From: Martyn White
Sent: 28 February 2019 12:44
To: Planning.Responses
Cc: Anita Gardner
Subject: M/153/18

M/153/18

The application is for 1 new dwelling with a detached garage within the Middleton-on-Sea estate. The estate has been identified as an Area of Character in the adopted Local Plan (2018), and as a consequence, is considered to be a non-designated heritage asset.

North Elevation 1:100 @A3

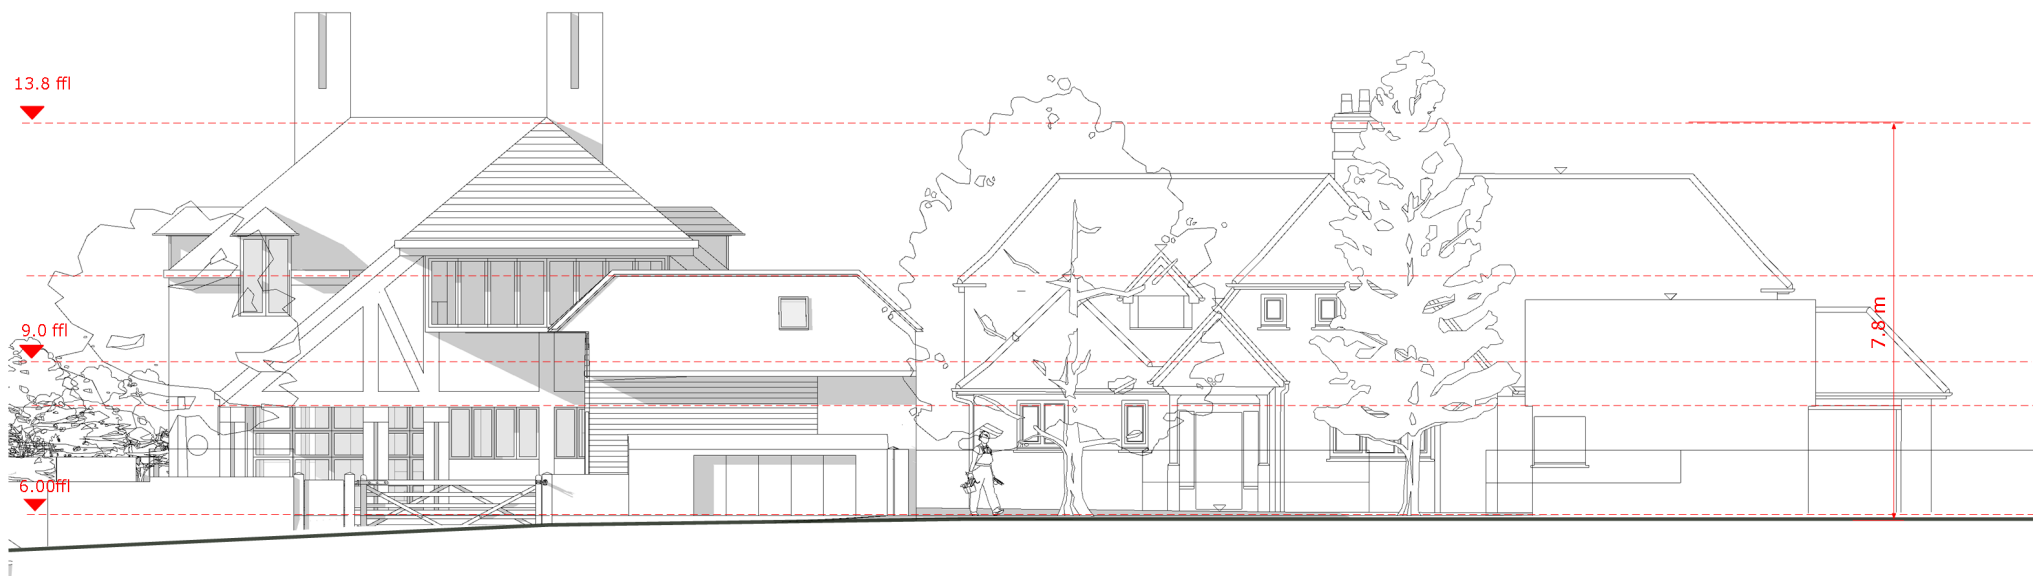
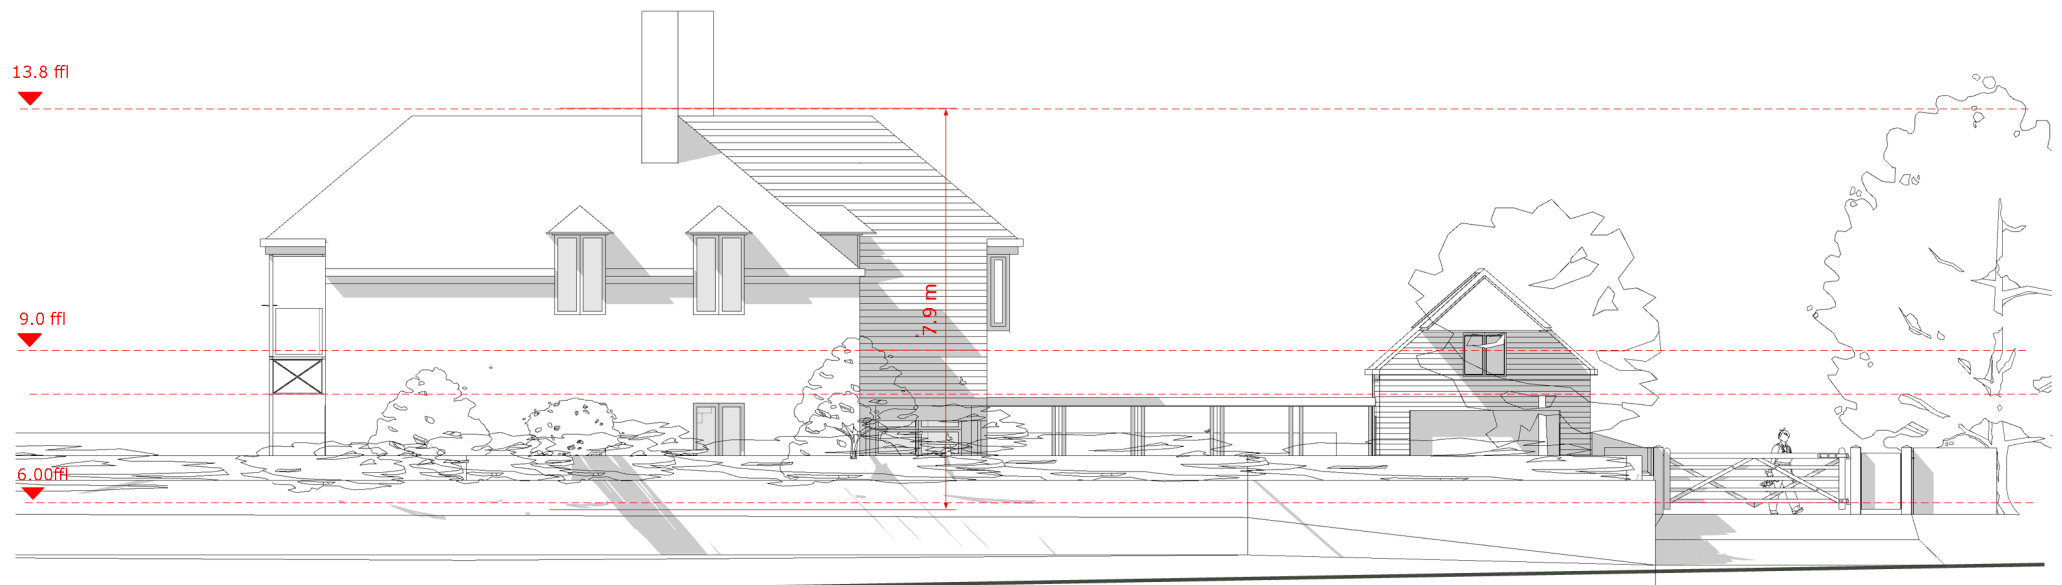
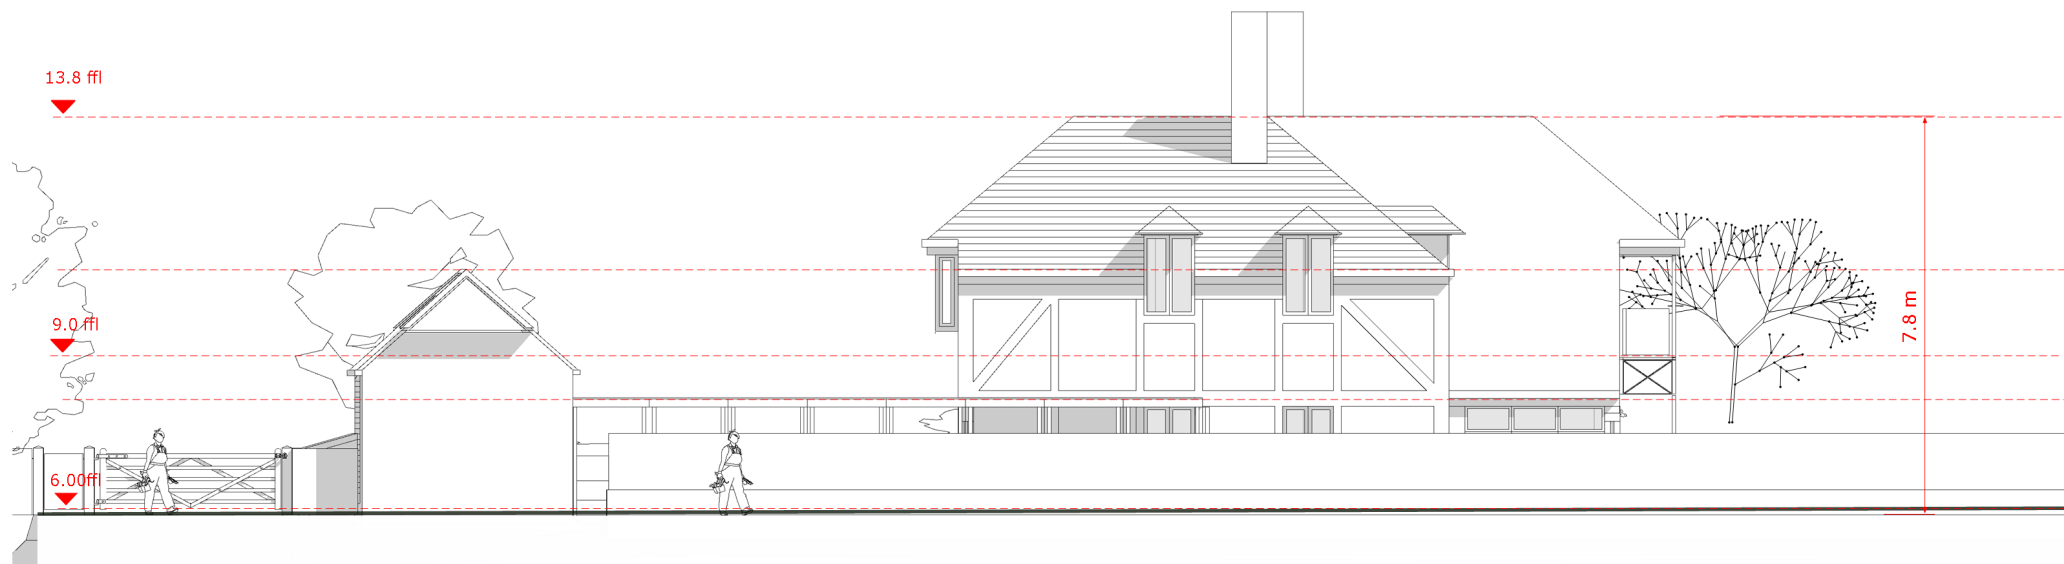
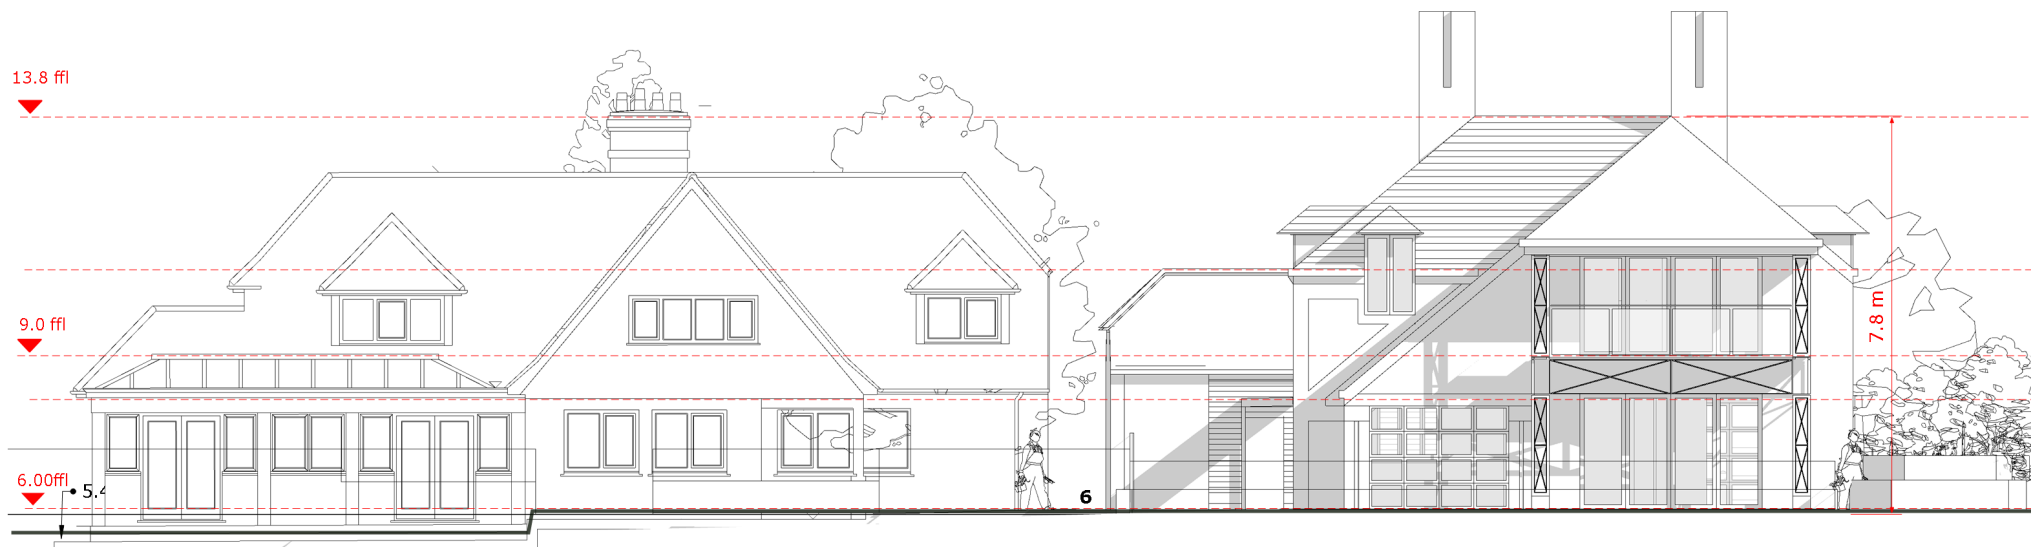
Whilst a more traditional appearance is proposed, it is not clear why a half-timbered elevation is now being considered, or why both slate and clay tiles are suggested, when the immediate properties are rendered with either clay or thatched roofs. It is considered that this, along with the stone quoining, glass balconies, shutters and roof, creates a series of complex elevations which would be in conflict with the established character of the local area.

I also note from the plans that there is an unusual structure added to the roof (in the centre). It is not clear what this is. Please can this be confirmed as it appears to be substantial in size, and could potentially have an impact on the appearance of the building?
